From: Chris Moore [REDACTED]
Sent: 17 January 2021
To: Amber Willard
Cc: 'Tom Barnes'
Subject: RE: Garages with Apartment above - Abergail, Clyde Road, Felpham - FP/231/20/PL
Attachments: Prop Plot Plan 200 1.pdf; Prop FF Plan 2.pdf; Prop Elevations 2.pdf; Site Location Plan 1.pdf; Streetscene Elevation 2.pdf; Ex Plot Plan 200 1.pdf; Prop GF Plan 2.pdf

From: Amber Willard [REDACTED]
Sent: 15 January 2021 13:45
To: Chris Moore <[REDACTED]>
Subject: RE: Garages with Apartment above - Abergail, Clyde Road, Felpham - FP/231/20/PL.

PROPOSED GROUND FLOOR PLAN

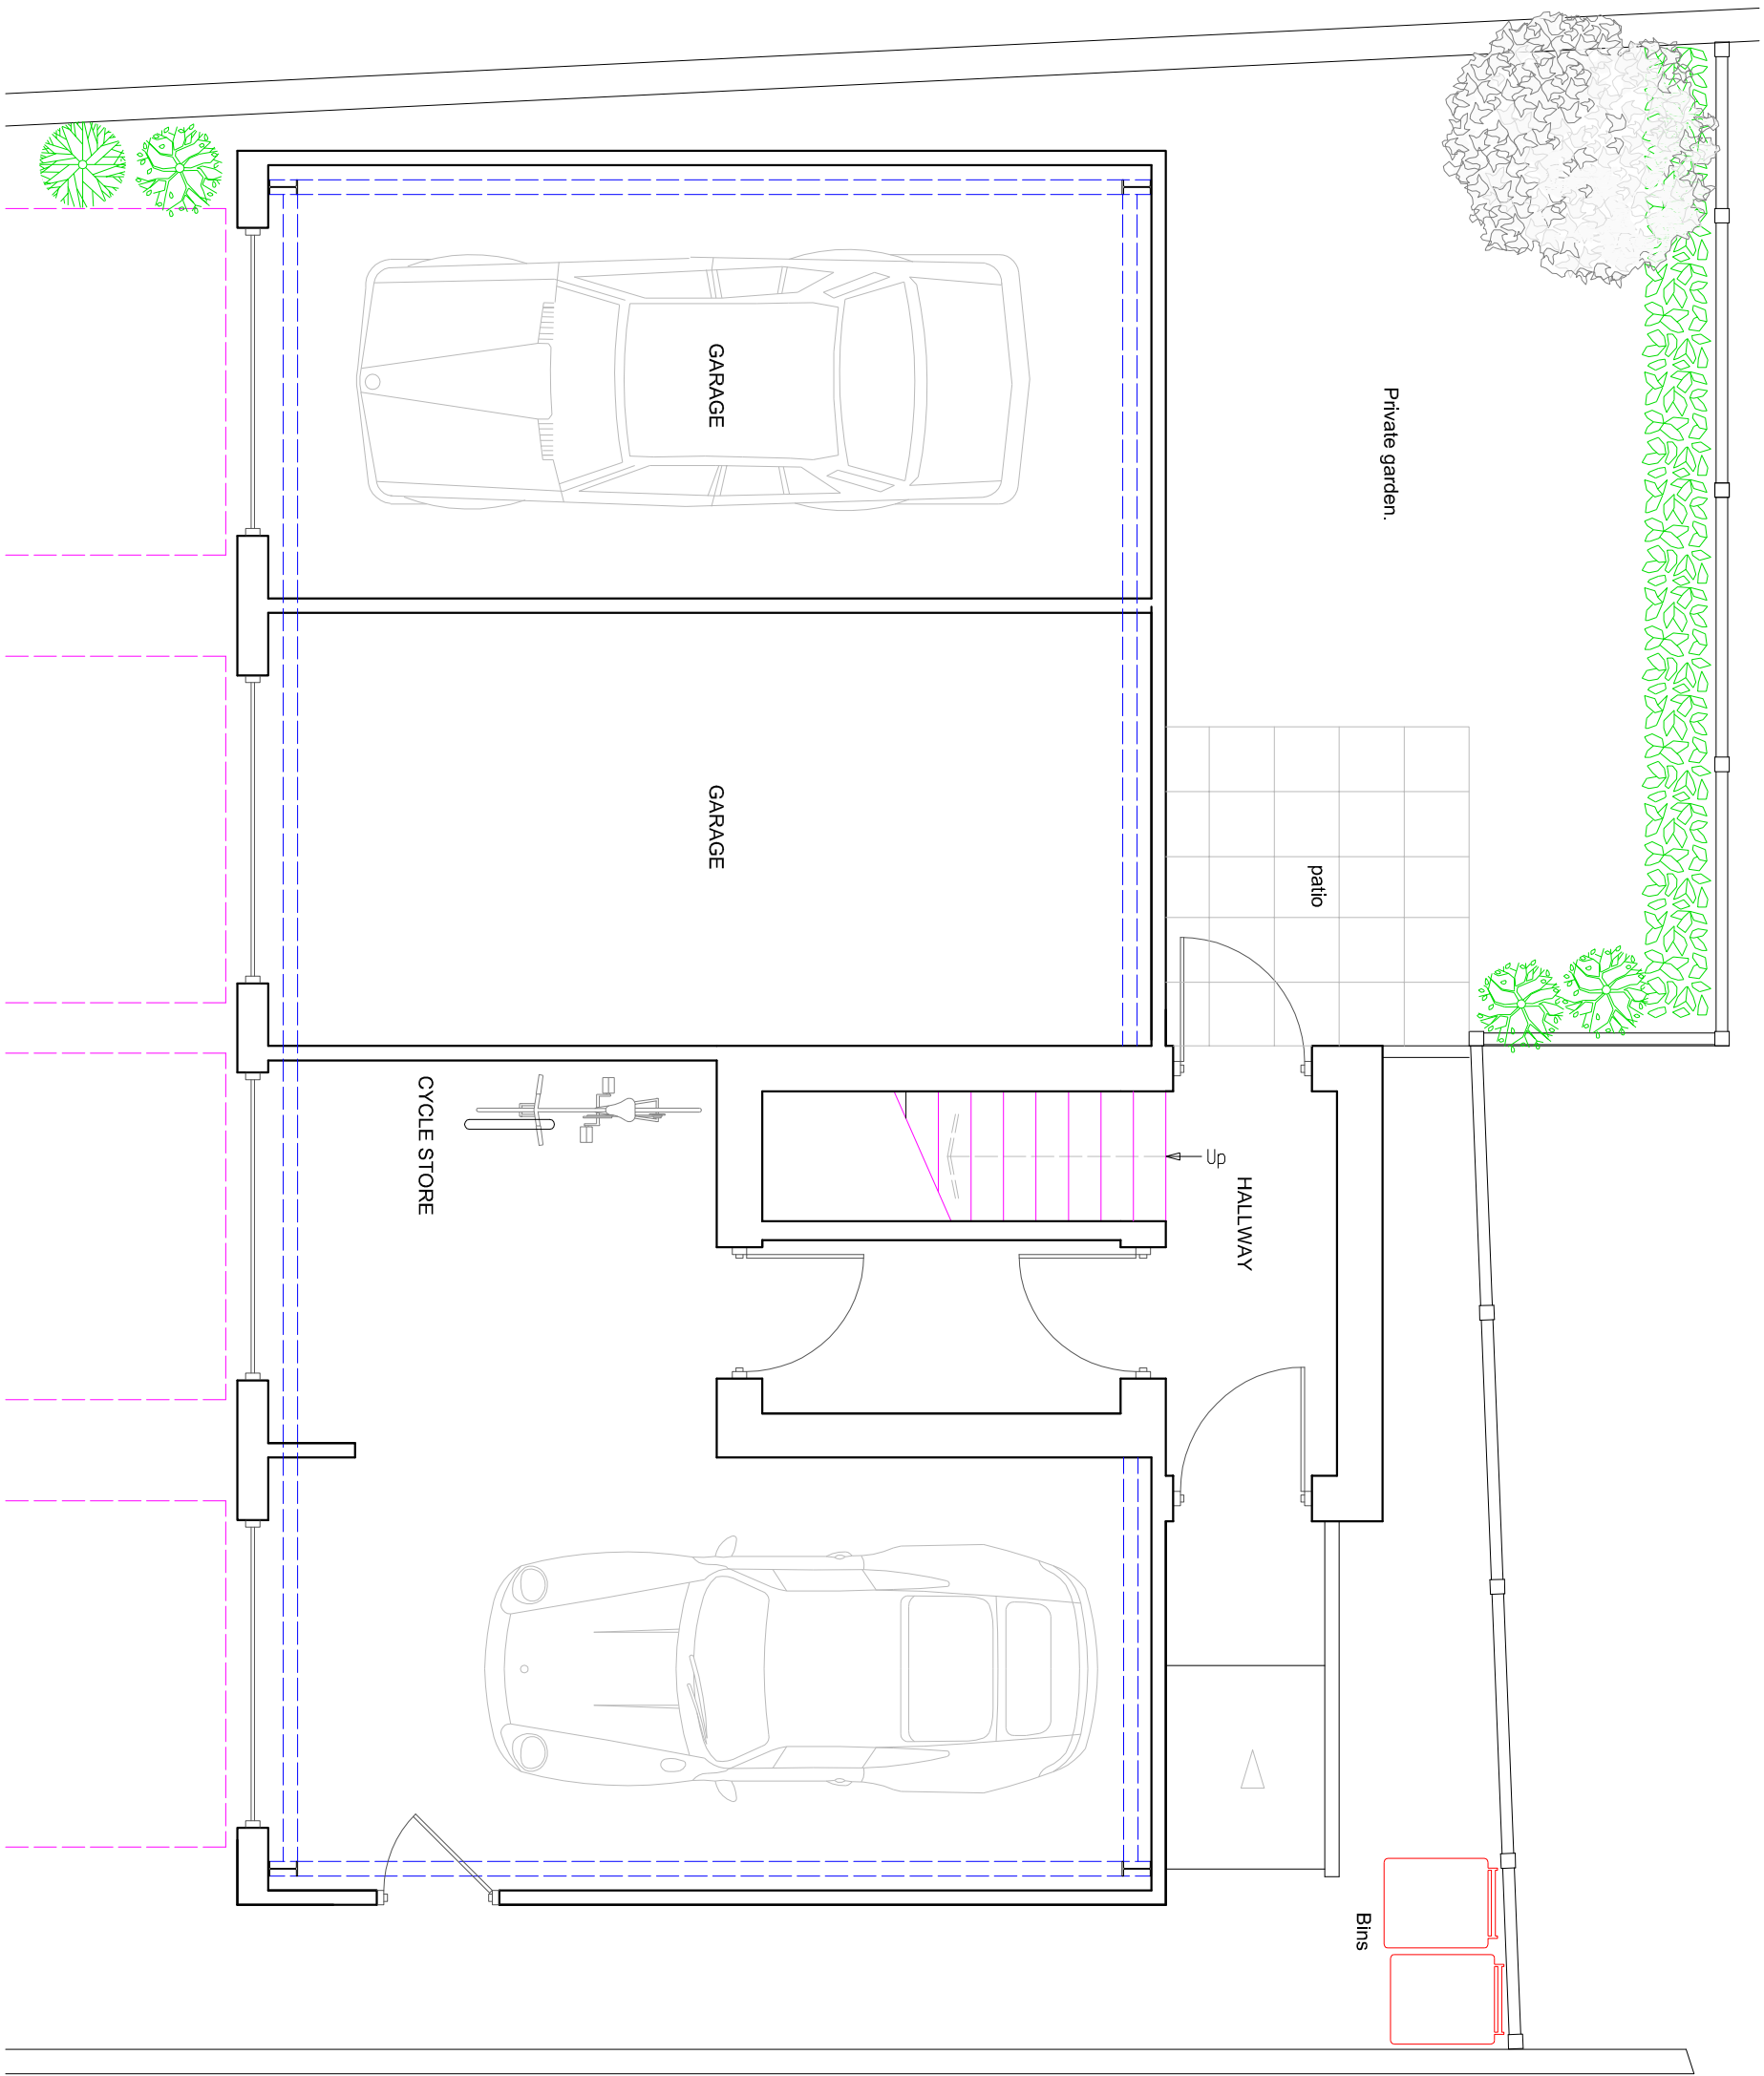
It would be good if the width could be amended to address the Parish objection. If you submit the plan to me, I can reconsult them or I believe you can contact them directly, and then you can check they would be happy to remove their objection prior to submitting the plan.

On another matter, we note that whilst all but one of letters received are in support of the development, there has been one objection, from the Parish Council on the basis of '*build is within 1 metre separation at first floor level of a neighbouring property, therefore is non-compliant with ADC's Policy Guidelines DM4*'.

I have been speaking with the applicant and we have decided to amend the drawings to ensure that the new building is kept a minimum of 1.0 metre from the boundary in order to seek the removal of the parish council objection and allow the decision to be made by delegated powers.

My client would like to make it known that he is prepared to reduce the width of the building in order to be able to maintain a 1.0 metre distance to that particular boundary if this would mean that the objection would be withdrawn and the application then to be decided under delegated powers by officers. If you feel that this is possible please let me know.

LOCATION PLAN - 1/1250

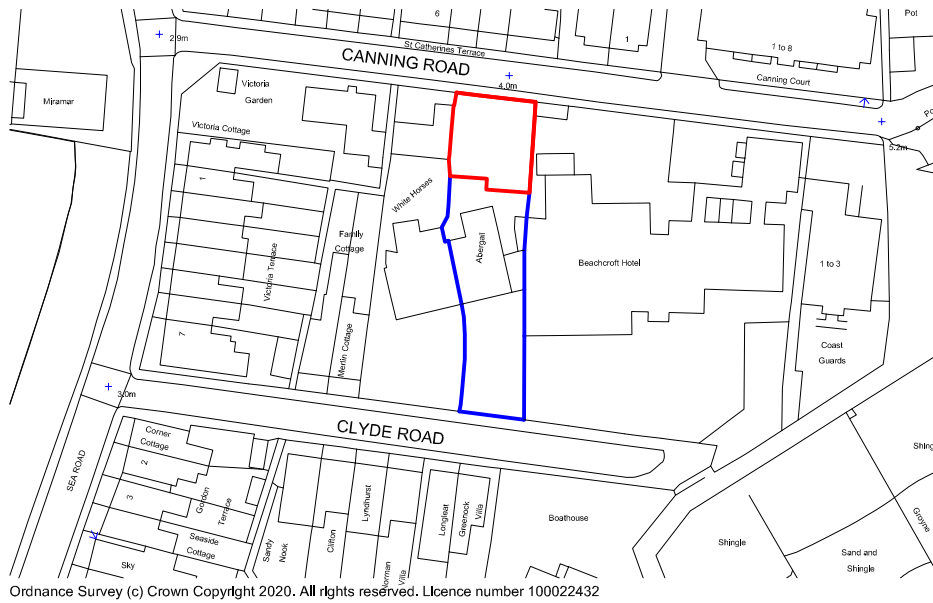
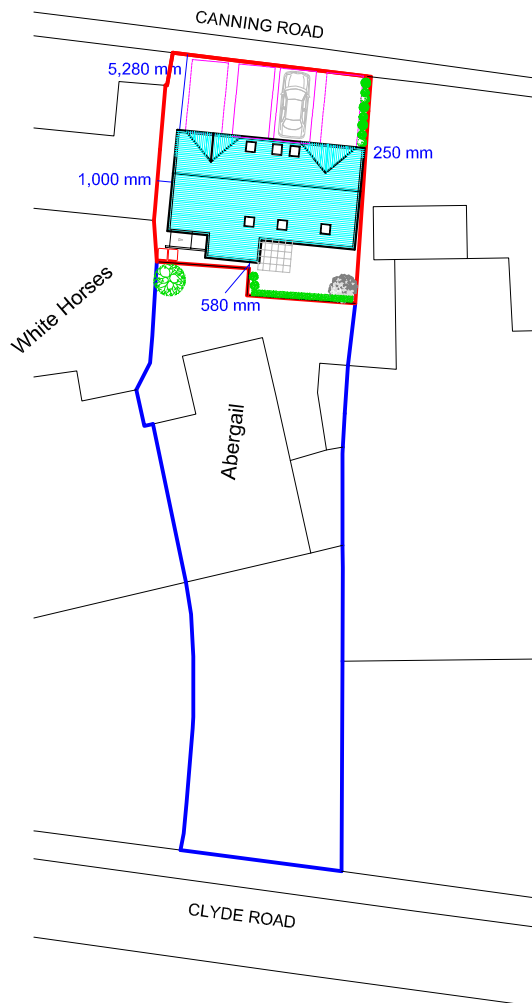
Also I received comments from our drainage department. These should be online although I copy the main bulk below. Currently they object however ask the blue line is amended which would ensure enough room on site to install the necessary drainage structures.

If infiltration is viable on the site then lack of space is not an adequate excuse for not utilising soakaways/infiltration structures. Soakaways must be located a minimum of 5m from any buildings, and 2.5m from the site boundaries. Given these constraints, it is not possible for surface water from the site to be sustainably drained within the red line boundary of the site. The applicant indicates an intention to drain surface water via a newly built soakaway in the front garden of Abergail within the same ownership but not within the application site.

It is understood that the applicant also owns the remaining plot for Abergail, (within the blue line boundary) and it is accepted that if the red line boundary was to be redrawn to include the indicated area in the front garden of Abergail then there will be sufficient space for surface water drainage. In this instance I would be happy to withdraw the objection and instead recommend the application of standard condition PCENG2

With the comments from the Council's Drainage Engineers, I have also amended the red edging indicating the boundary extent as the soakaways for the new building will be located on this part of the plot.
